**MANAGED GROWTH AND COMMUNITIES  
DIRECTORATE**

Your ref: PL/2019/01591/COU

**PROPOSAL:** Change of use for part of garden adjacent to property to be established as an OFSTED registered outdoor nursery (12 places). The facility will operate solely from the garden and will not require access to any part of existing property or the erection of any buildings on site. The children will shelter in the tipi tent or under tarpaulins erected during bad weather.

**LOCATION:** Four Oaks, Back Lane, Meriden, Solihull.

Crown copyright 2014. Supplied by UKPlanningMaps.com a licensed Ordnance Survey partner (100054135).  
**BLOCK PLAN 1:500**

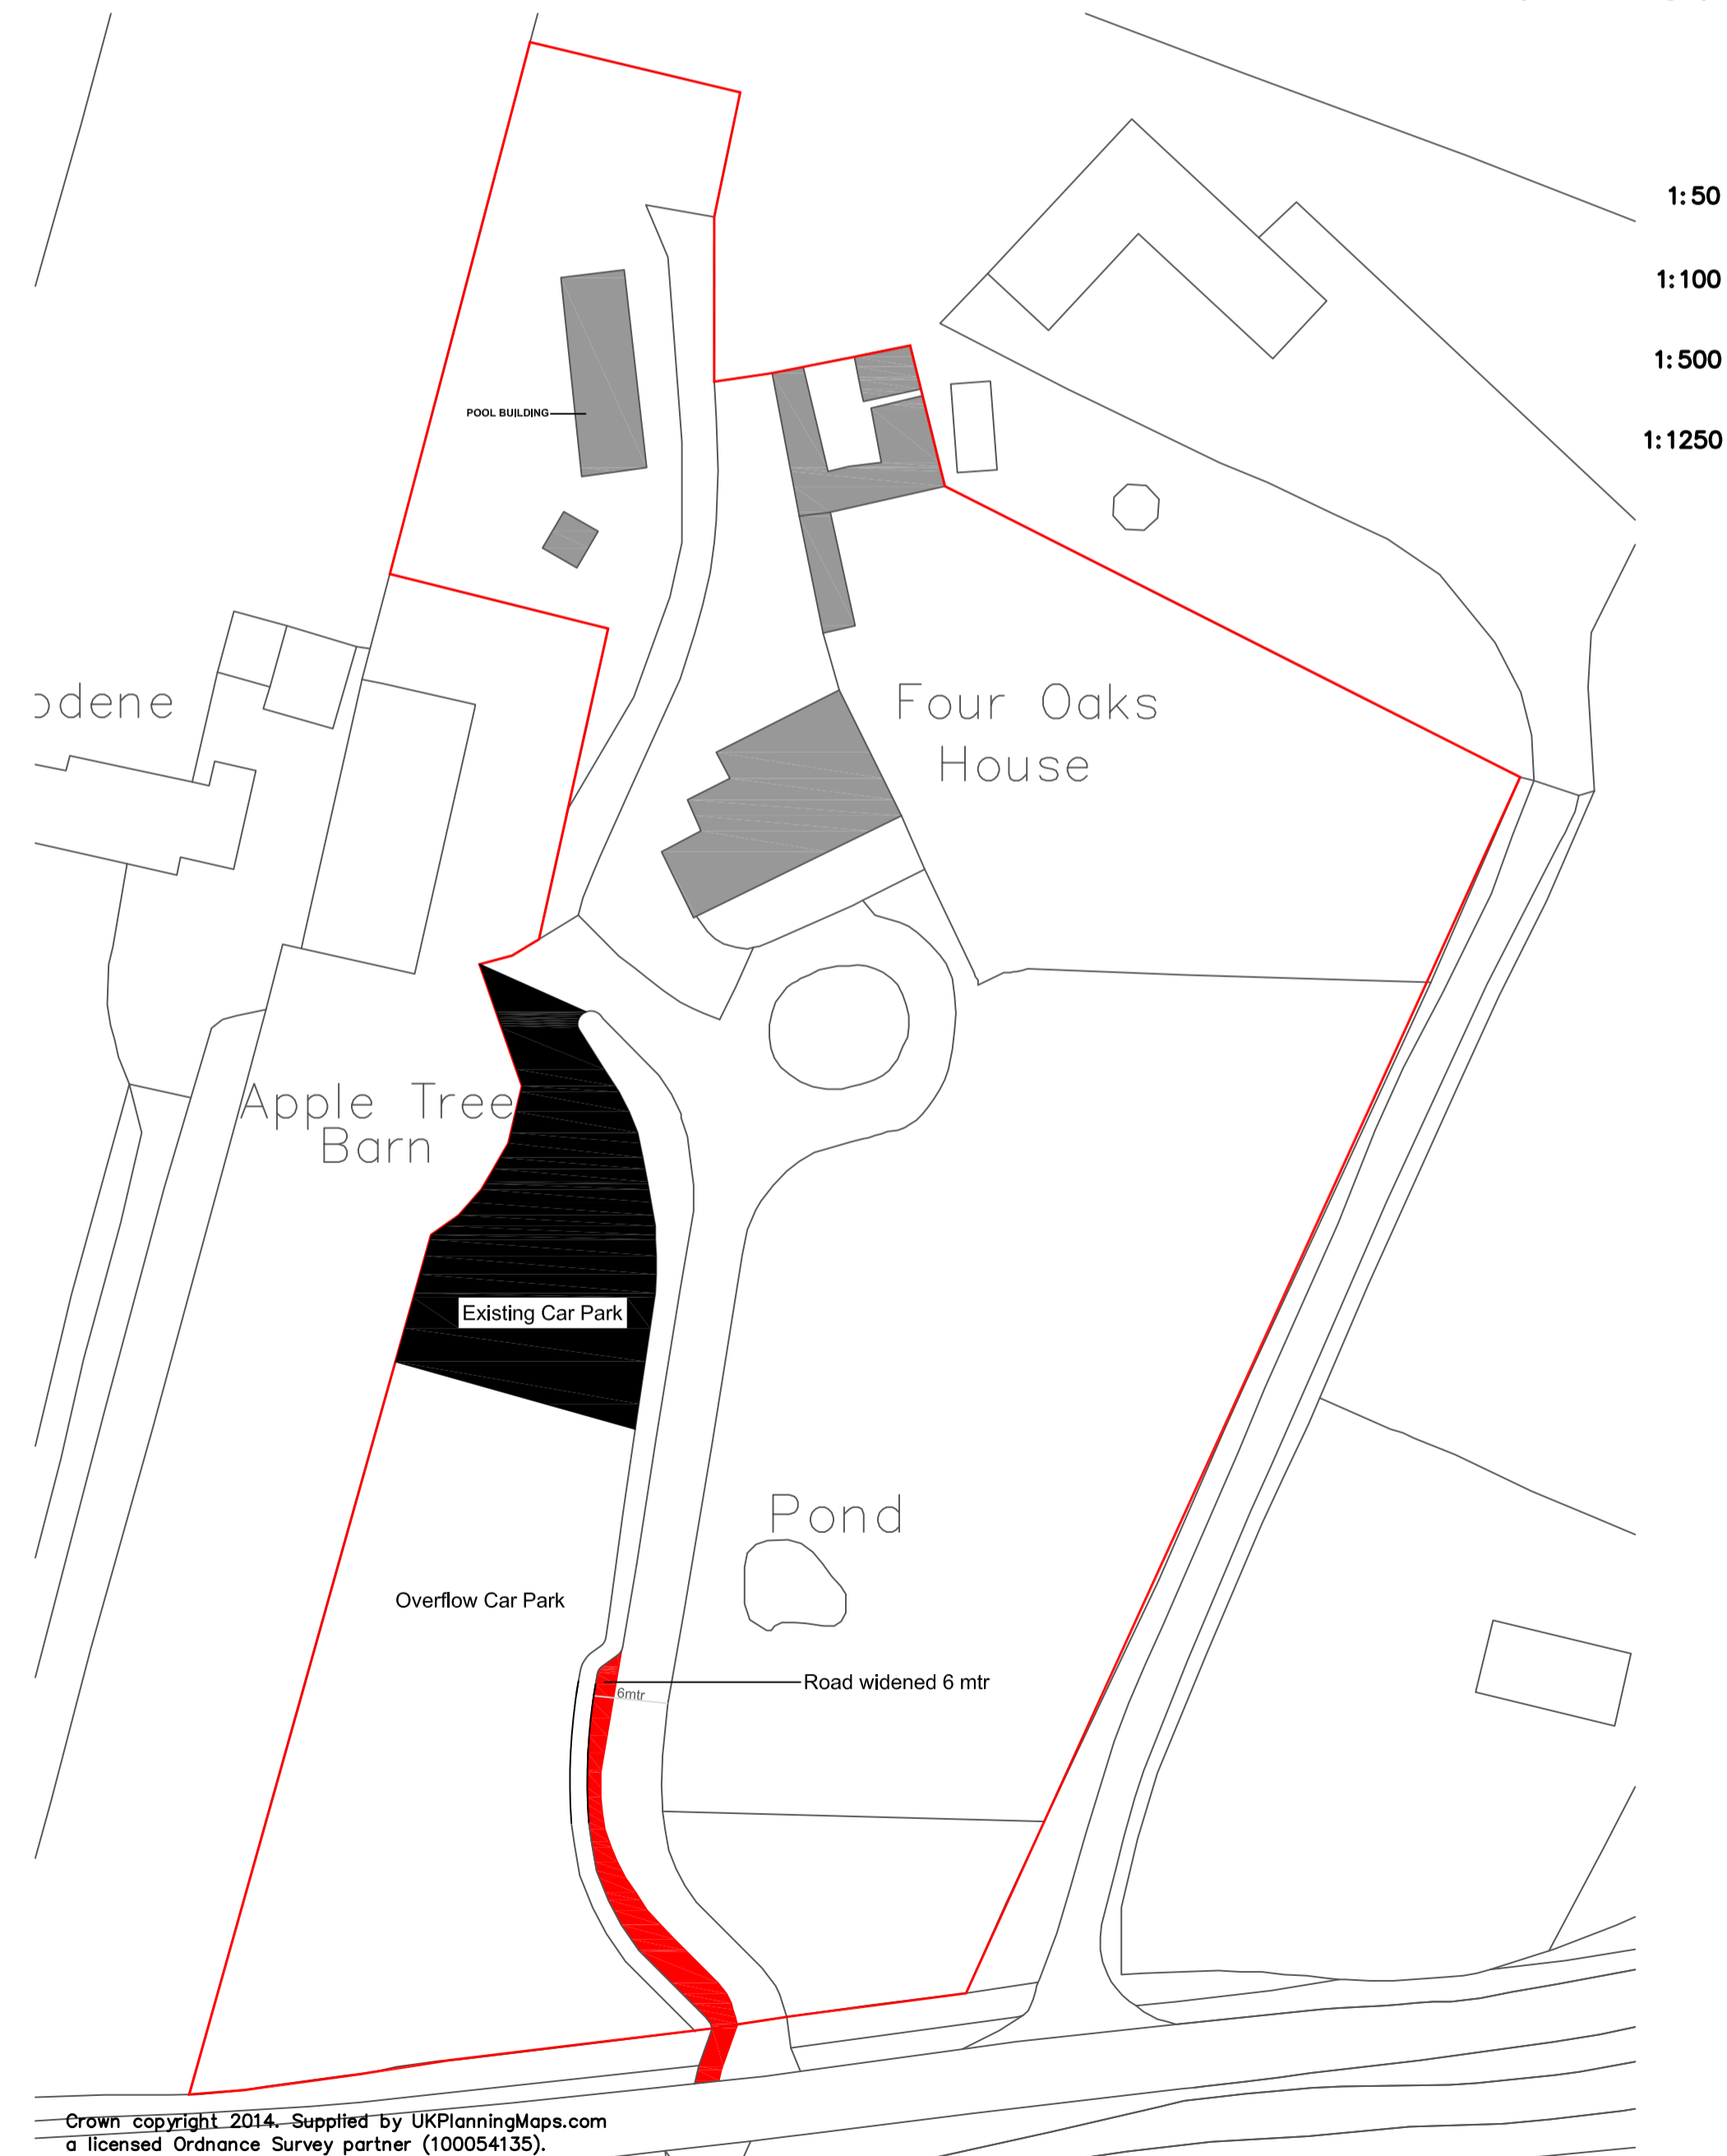
There is an existing vehicular access into the application site off Back Lane, which measures approximately 3.8m in width, when measured at the gates. The development proposals will increase the number of vehicles using the vehicular access, increasing the potential for two vehicles to meet at the access. The Highway Authority would therefore require the vehicular access to measure at least 5m wide, for a minimum distance of 7.5m as measured from the near edge of the carriageway. This will enable two vehicles to pass each other within the vehicular access.

At the existing vehicular access, Back Lane is subject to a 40mph speed limit requiring visibility splays of 120m to be provided in both directions, when measured 2.4m back from the near edge of the carriageway. Visibility splays of approximately 90m can currently be achieved to the right (west) of the existing vehicular access, when measured 2.4m back from the edge of the carriageway, and visibility splays of approximately 75m can be achieved to the left (east).

The Highway Authority considers the existing vehicular access to be below standard, and the development proposals will intensify the use of the below standard access, potentially to the detriment of public highway safety.

1. The existing vehicular access is considered to be below standard and the development proposals will intensify the use of the below standard access, potentially to the detriment of public highway safety. It is therefore considered that the development proposals fail to accord with Policy P8 of the Solihull Local Plan 2013, and Paragraphs 108 and 109 of the National Planning Policy Framework (February 2019).
